Ribble Valley Borough Council  
Council offices  
Church Walk  
CLITHEROE  
BB7 2RA  
My reference: 3/2025/0271

Location: Lower Reaps Farm Whinney Lane Mellor BB2 7EL

Proposal: Approval of details reserved by conditions 3 (materials), 4 (window and door specifications), 5 (details of roof lights), 6 (sections), 7 (building recording and analysis), 8 (external meter boxes) of listed building consent 3/2022/1166.

dis.03

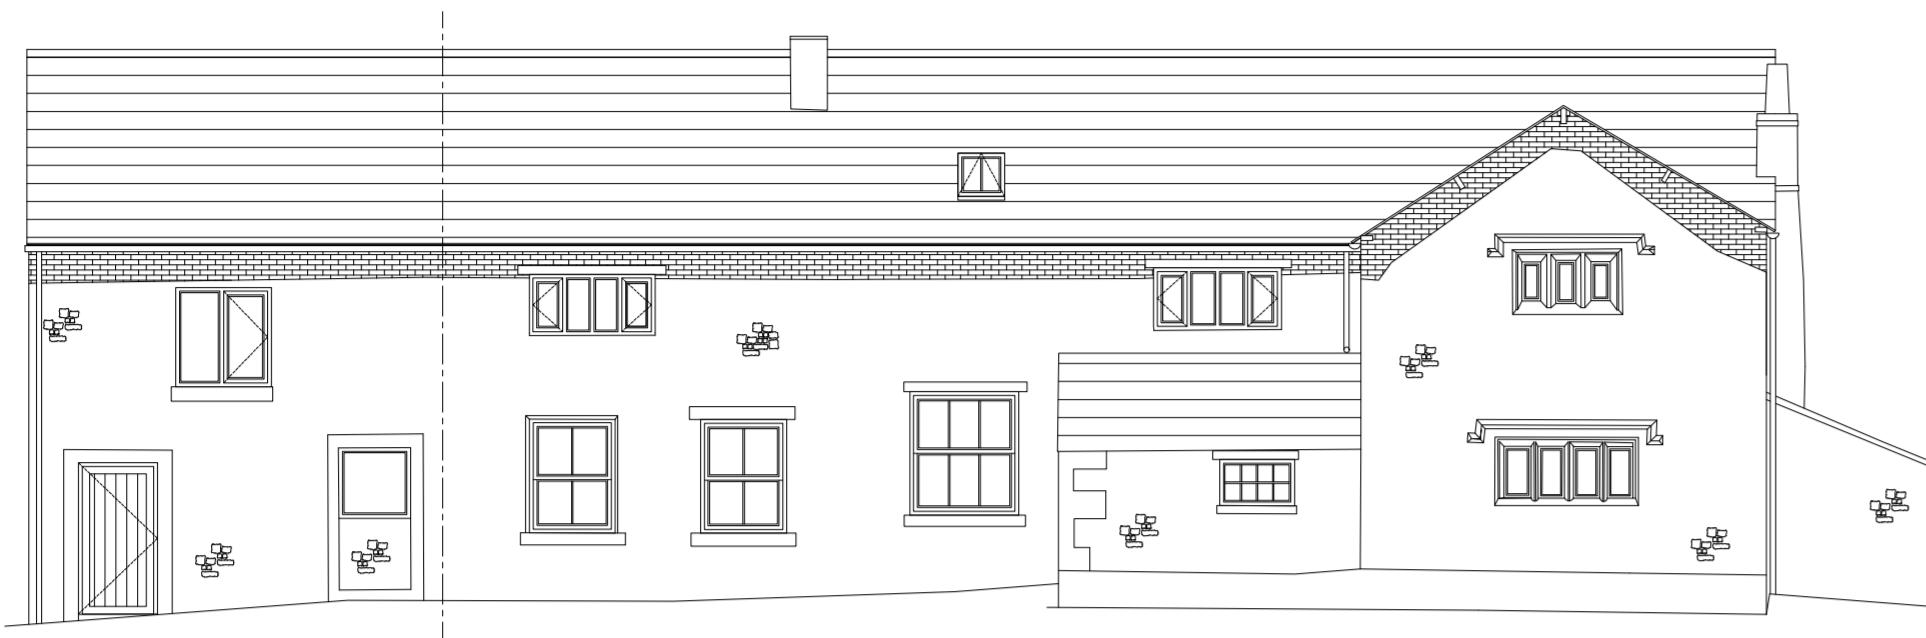
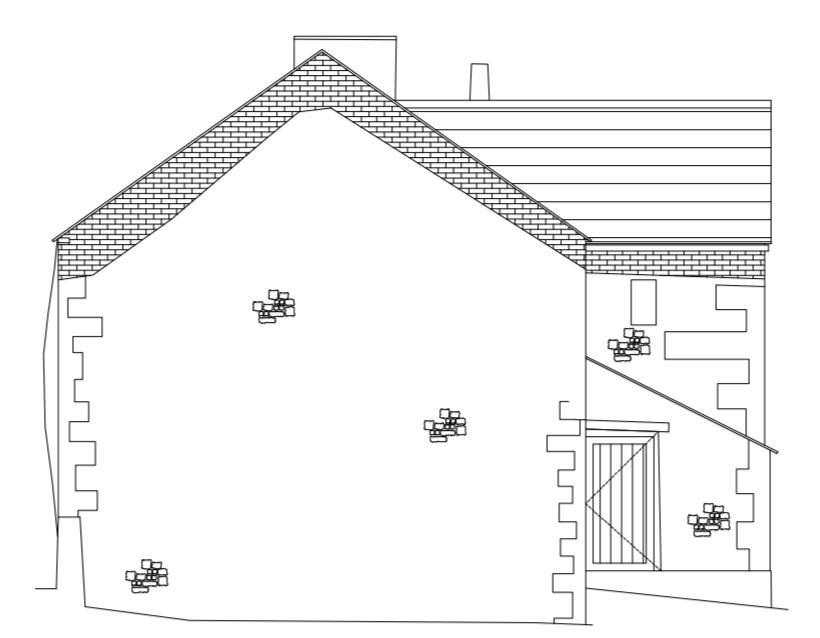
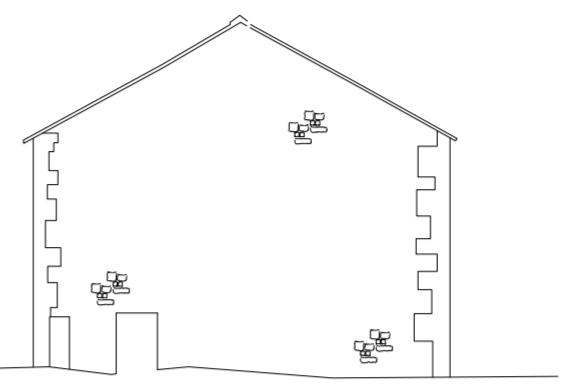
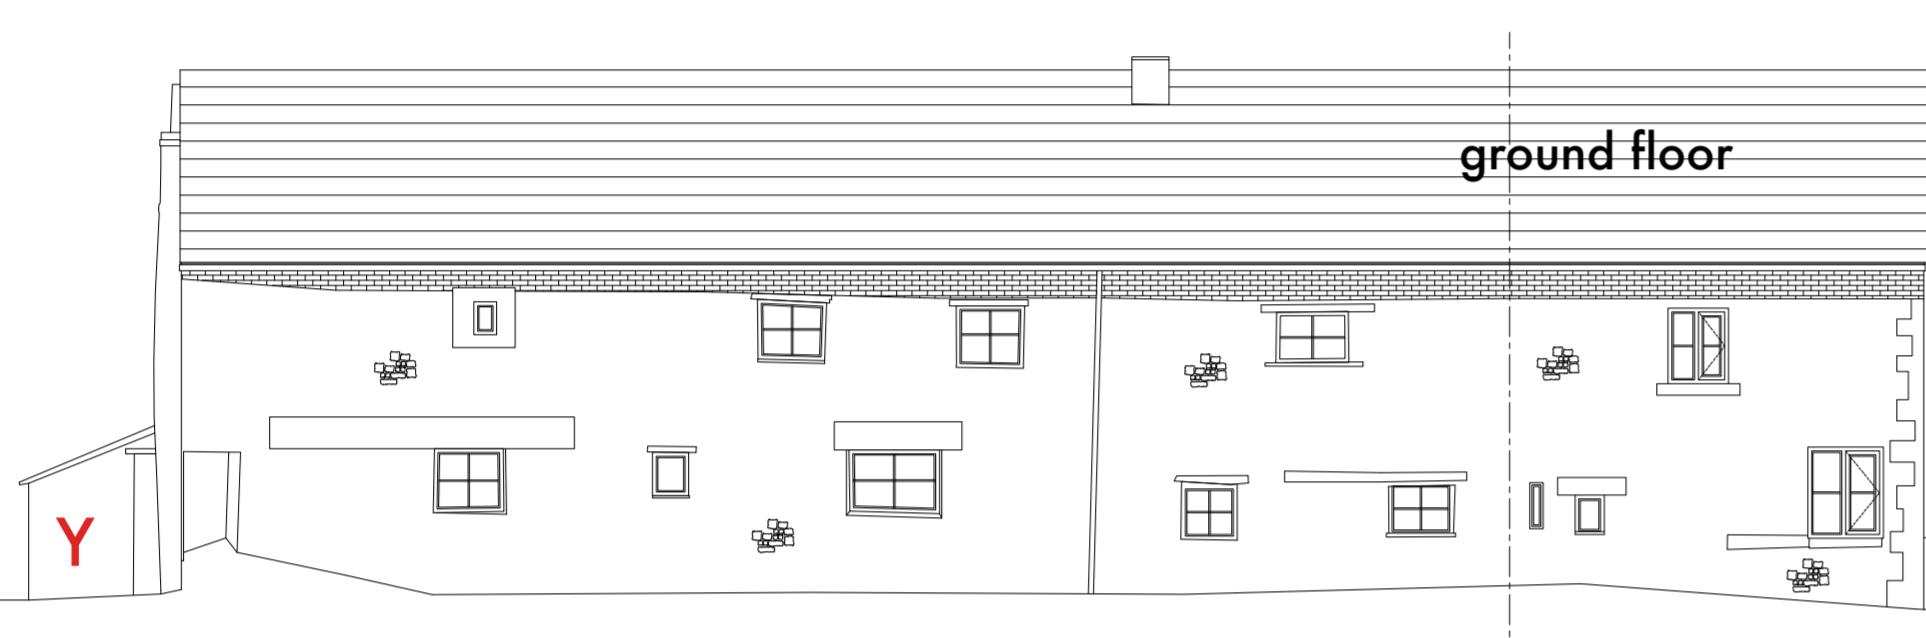
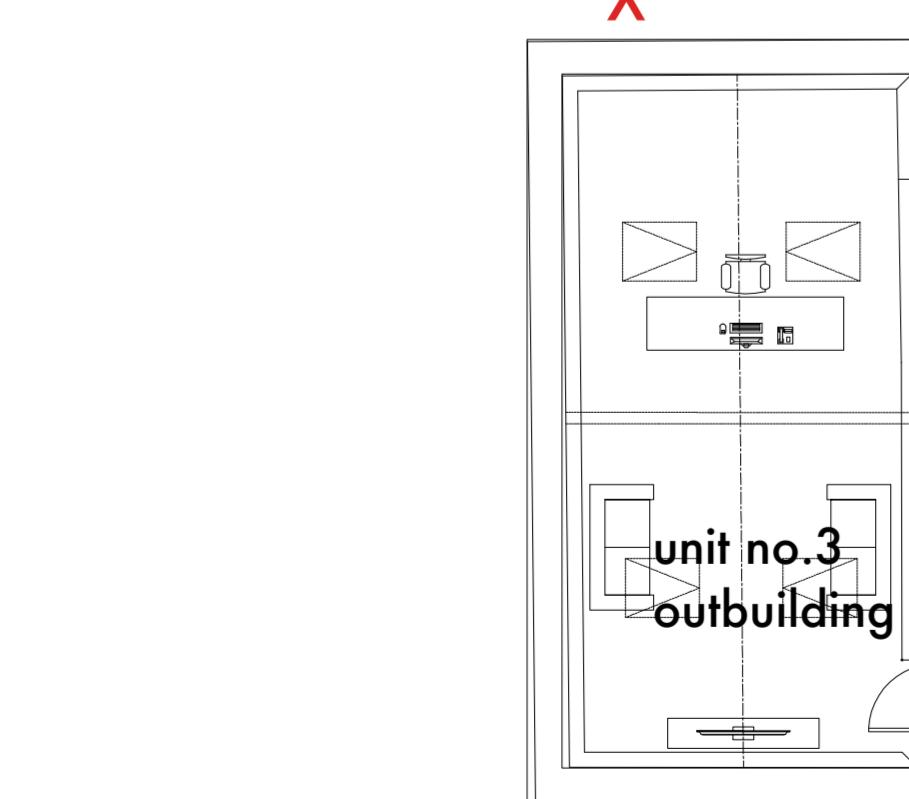
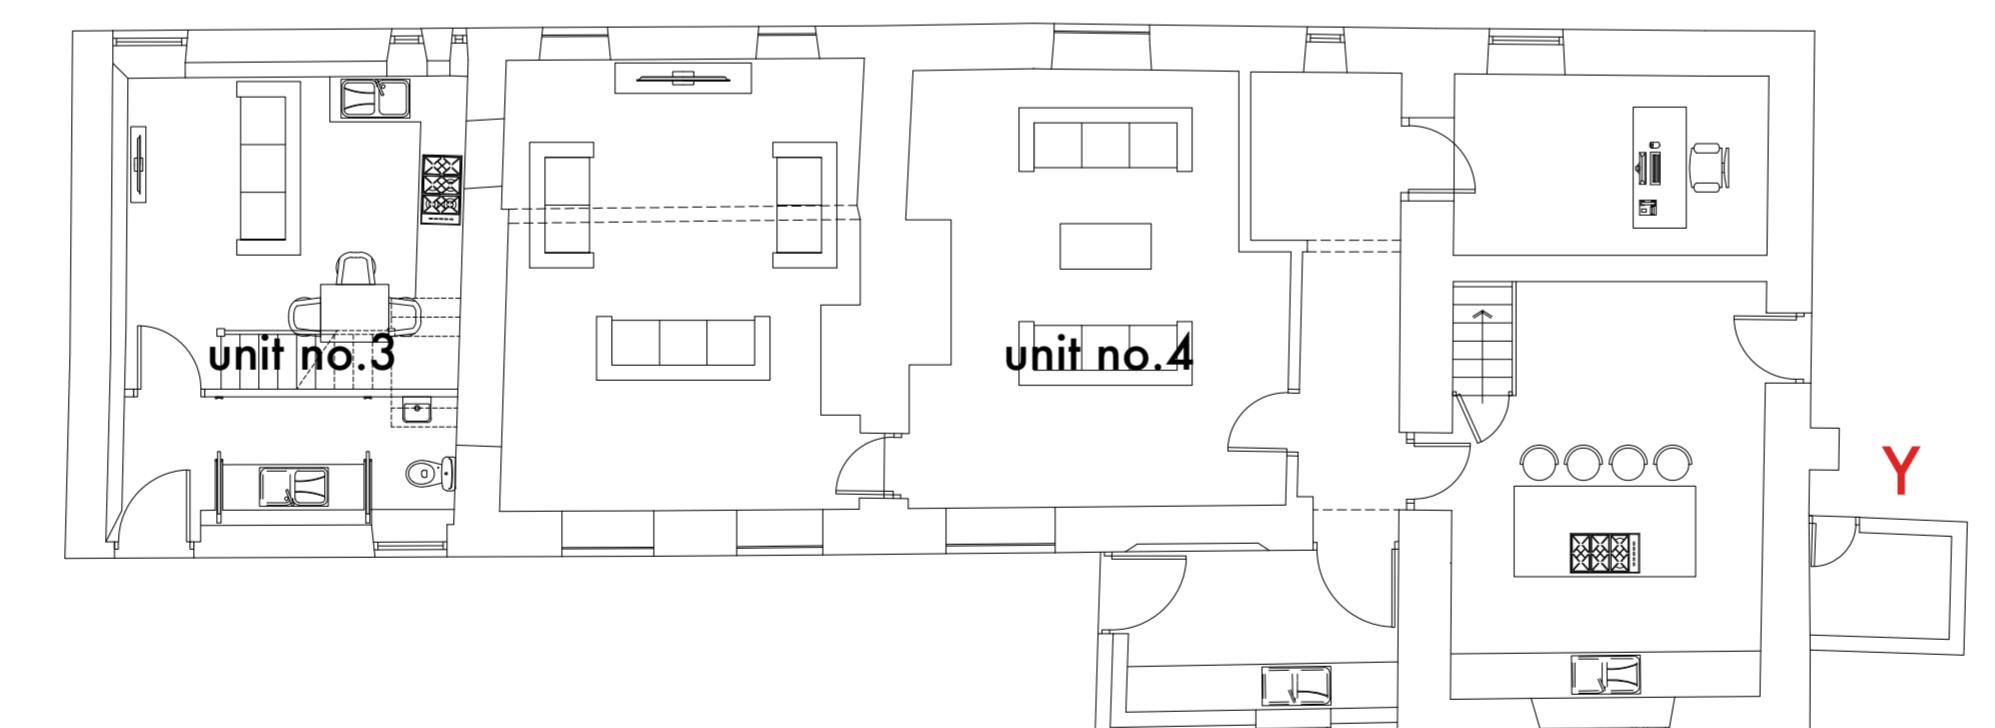
**Condition 8 (external meter boxes)** - The design and location of the proposed meter boxes as indicated in drawing ref: dis.03 is acceptable. Condition 8 can therefore be partially discharged insofar that the development shall be carried out in strict accordance with the approved details unless otherwise agreed in writing by the Local Planning Authority.

Walling stone and mortar:

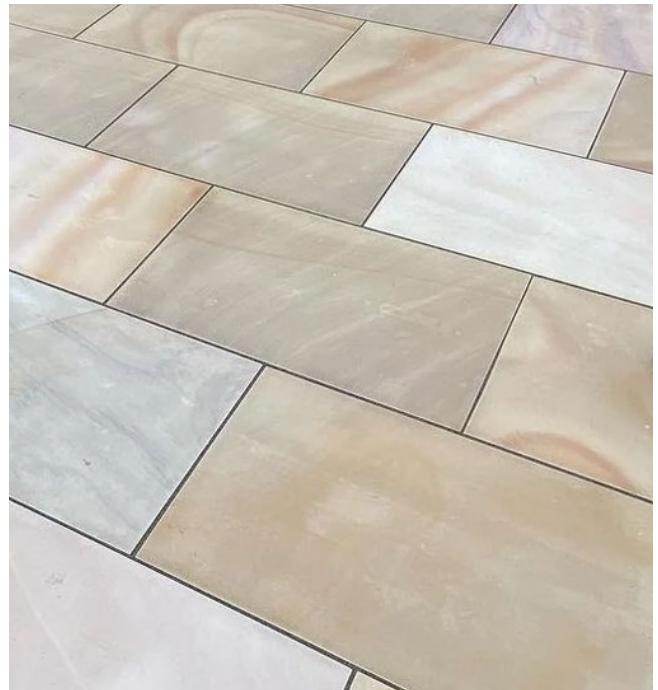
- The proposed doors will be made of hard wood and painted; the finish is to match hard wood windows, and the material and design acceptable.
- The photographic sample of the stonework for the walls, which is to match the existing and any new stone to be locally sourced / reclaimed is acceptable, however the proposed mortar mix details for any repointing has not been provided. This is not acceptable and is required to be submitted.

Internal flooring:

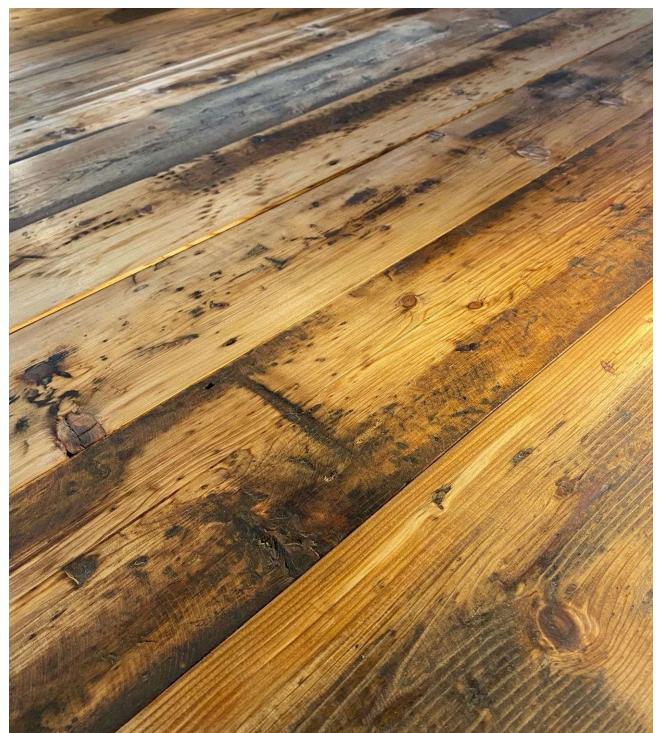
- The proposed internal and external floor treatments are satisfactory and considered acceptable.

Roof:

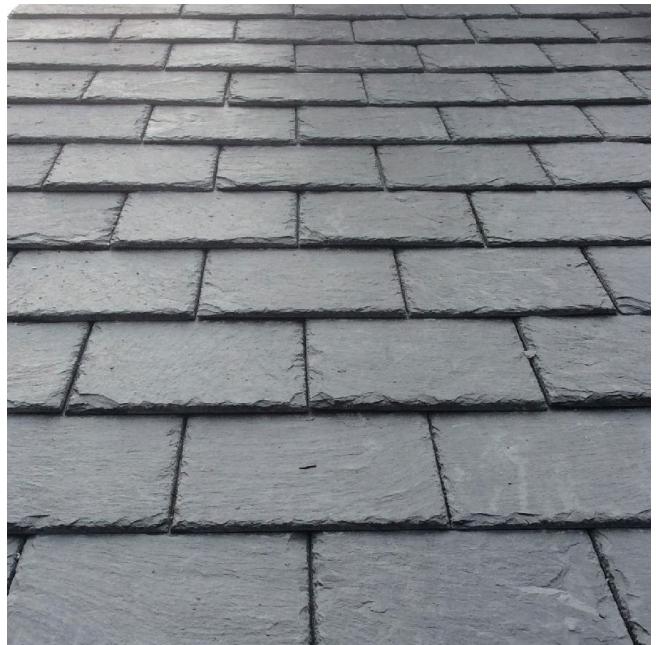
- The proposed roof finish is to be of a blue/grey natural slate to suit locality - slates to be UKCA marked which confirms they have been tested to BS EN 12326 and are grade T1 classification and are acceptable.
- The aluminium rainwater goods in heritage black are acceptable
- No details have been provided of the opening to be in-filled including reveals. Blocked up entrances should be set back in the reveal; this is to evidence the former opening, to allow the building still to be read and understood. These details are required to be submitted.
- No material details for lintels and cills have been provided. These details are required to be submitted.
